RE: **Vigil 3 Dwelling Units**
12904 Kachina Pl NE
Grading and Drainage Plan
Engineers Stamp Date 8/8/17 (H23D012B)

Based upon the information provided in your submittal received 8/22/2017, the above referenced Grading and Drainage Plan cannot be approved for Grading Permit or Building Permit until the following comments are addressed.

GRADING AND DRAINAGE PLAN

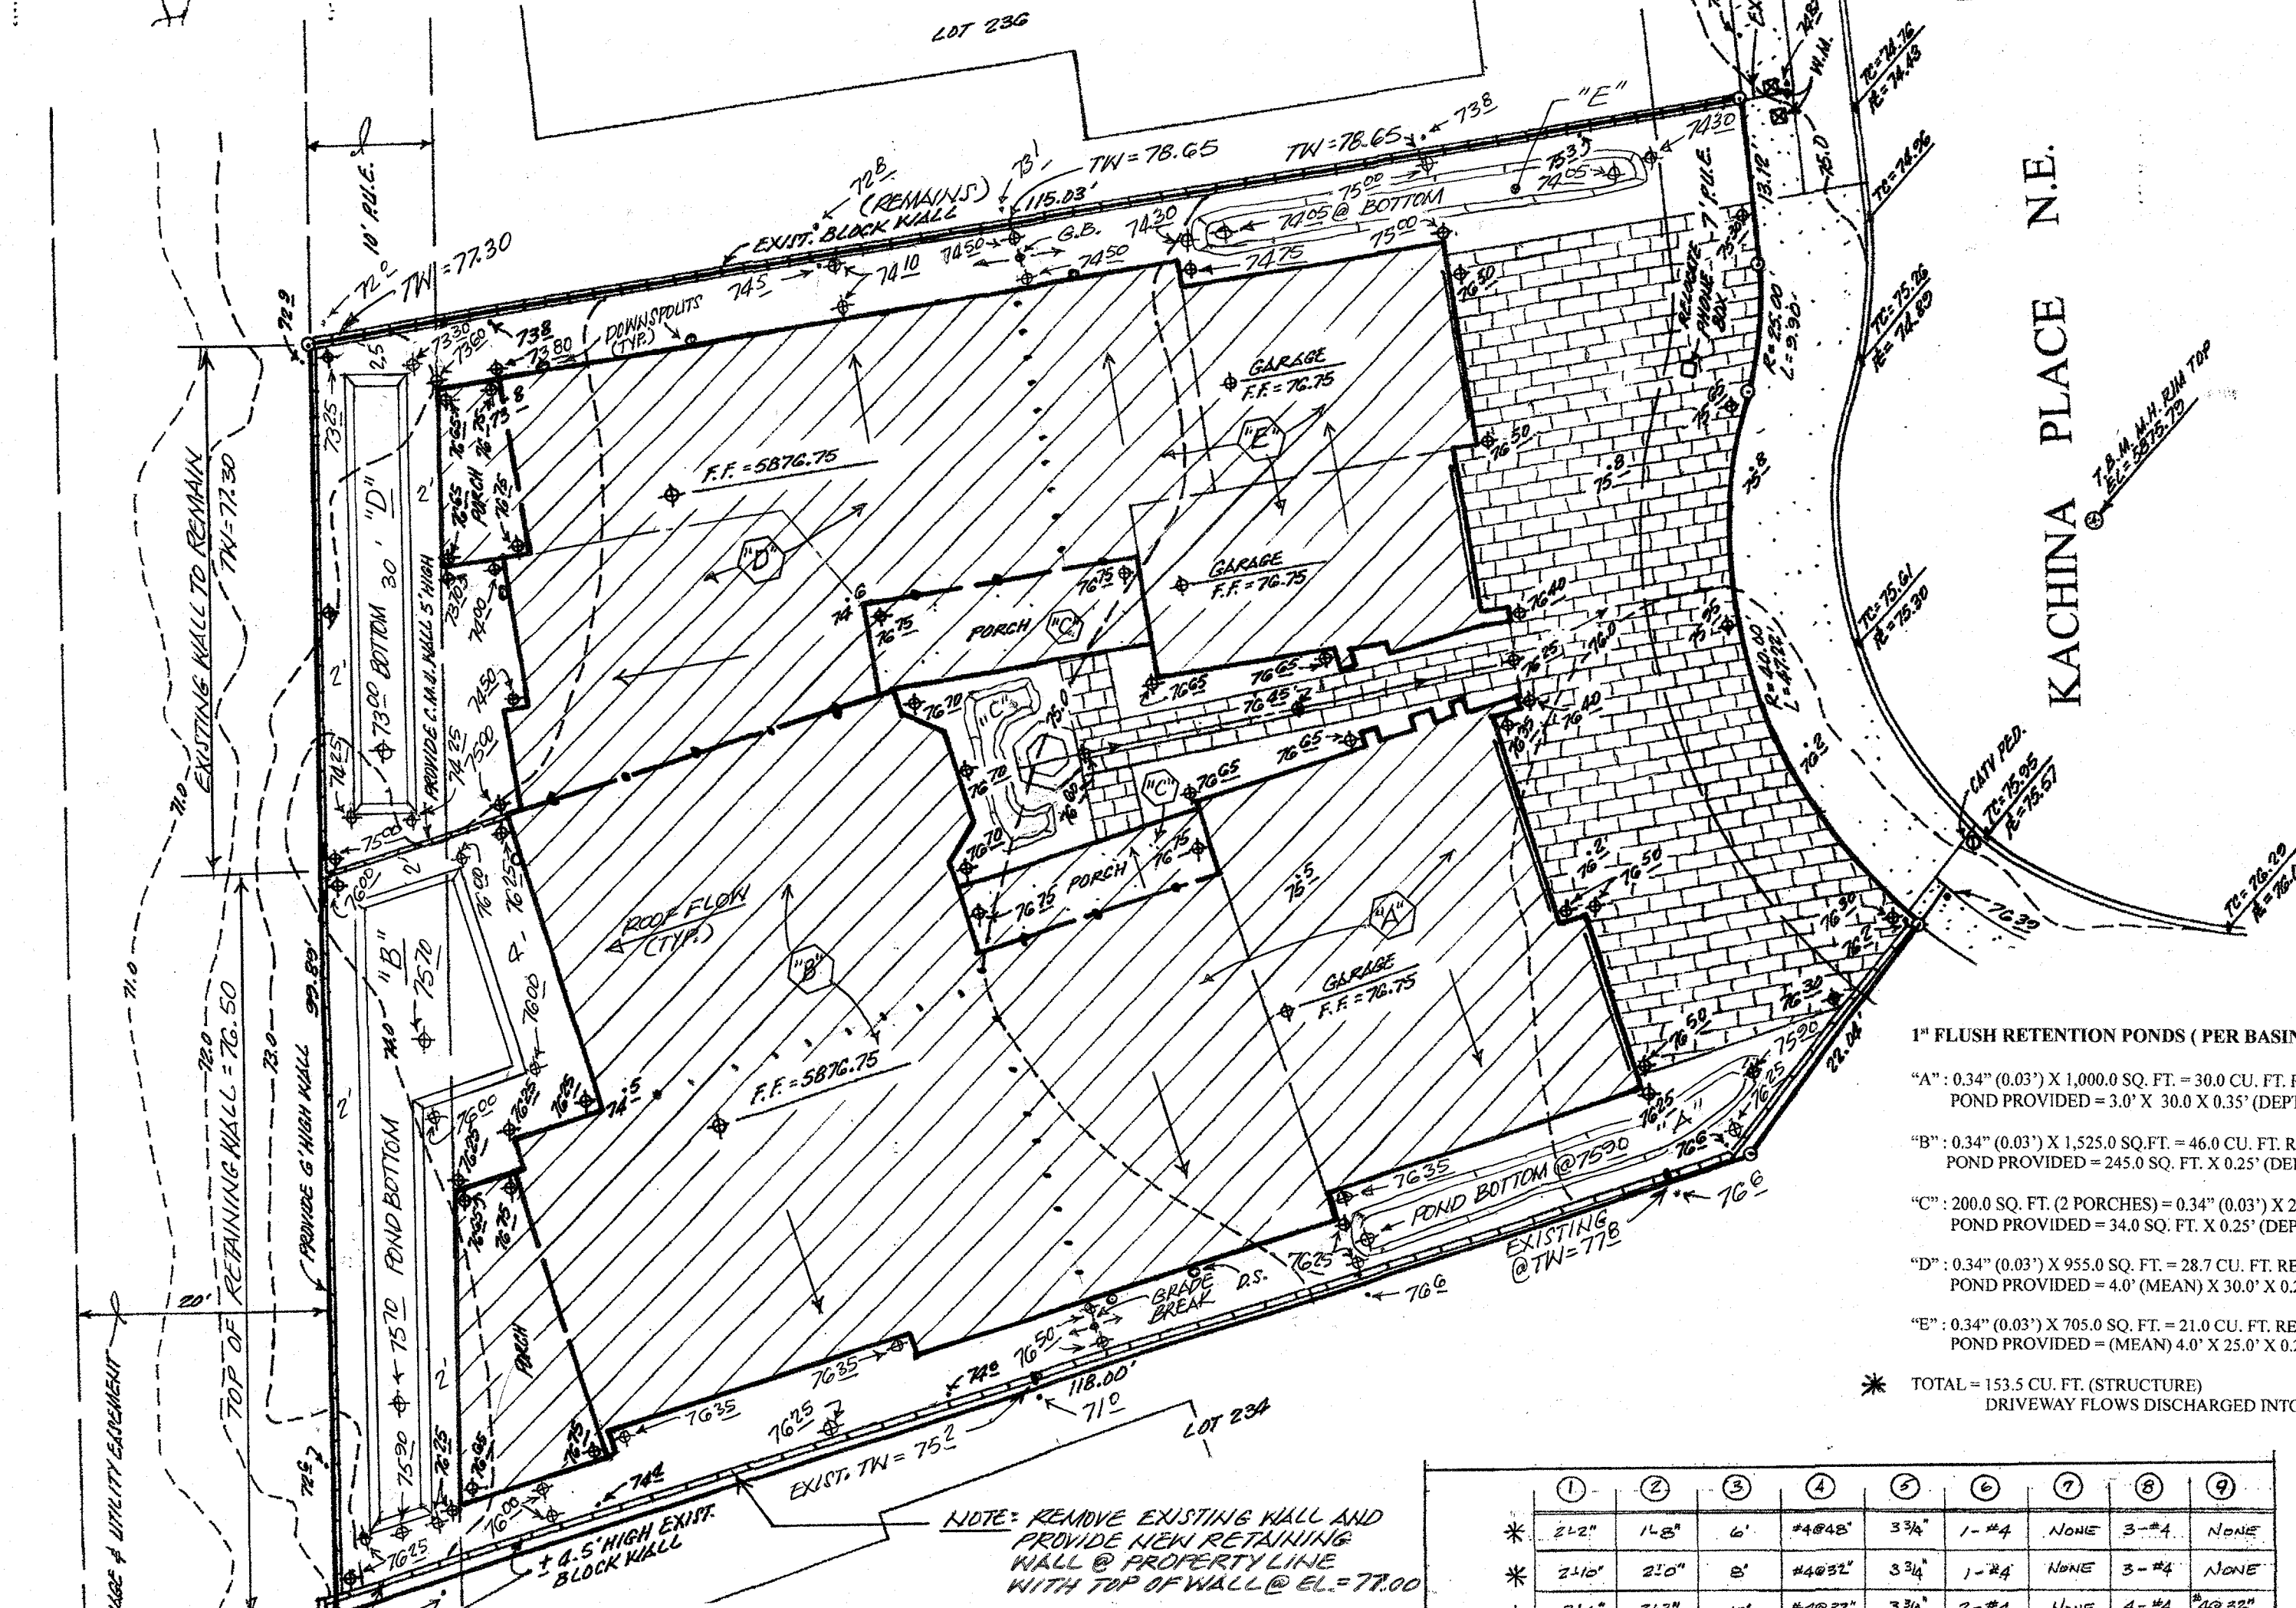
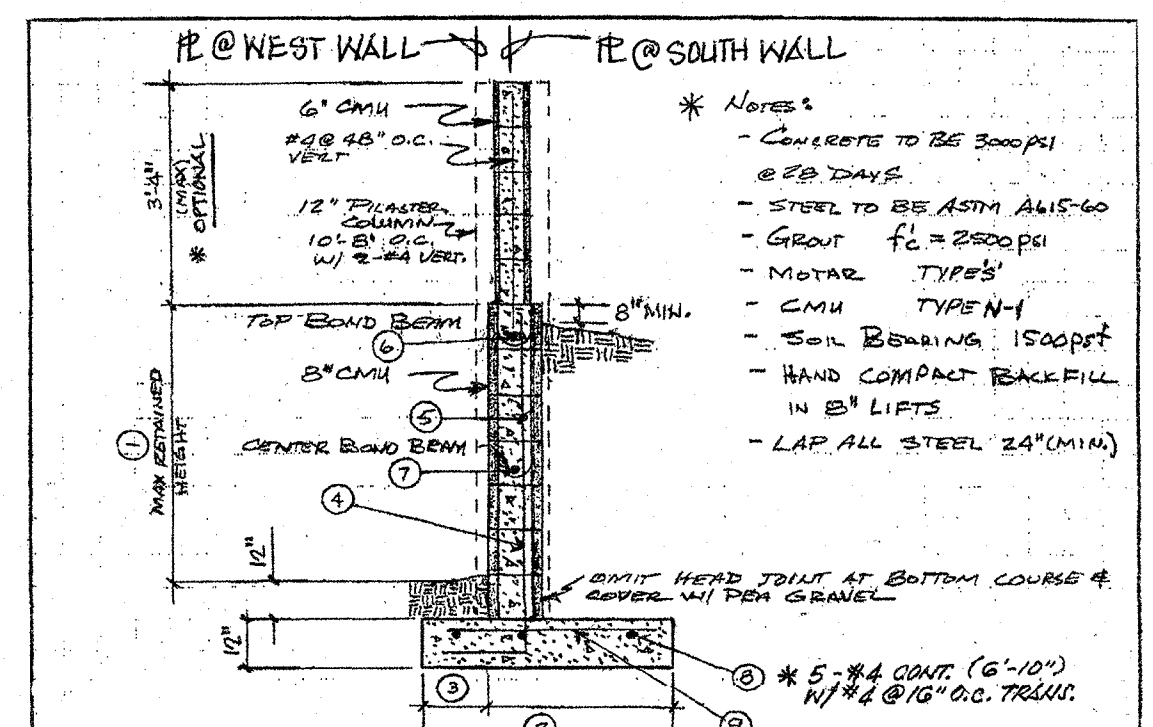
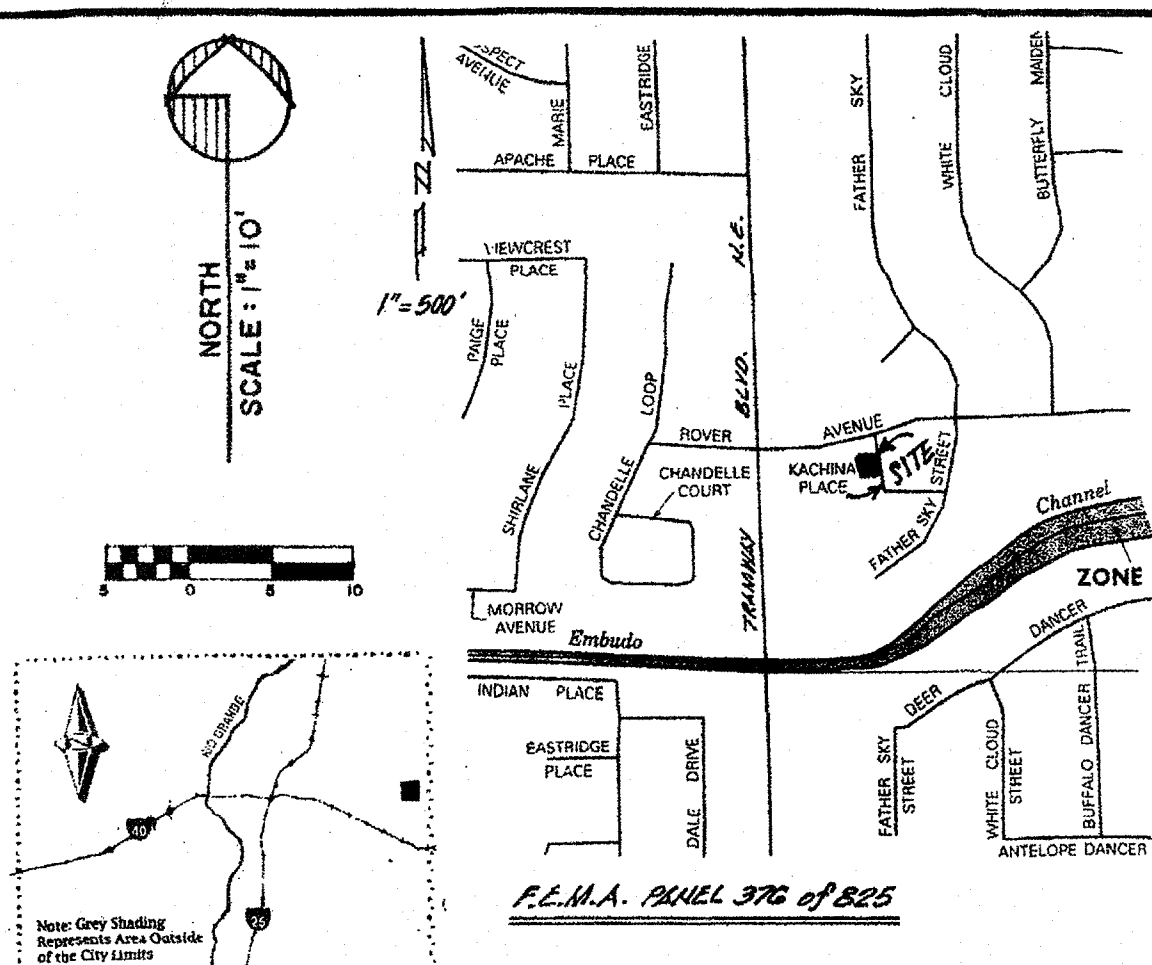
- The footing on either side of the wall must remain on the property of the owner, unless written approval is granted from the abutting neighbor which will allow for the footing to encroach onto their property. Here is an excerpt from the Development Process Manual addressing this matter; "... Care should be taken to ensure that existing foundations, retaining walls, stable slopes or other structures are not endangered and that the adjacent property is not damaged or it's use constrained due to grading at or near the property line."
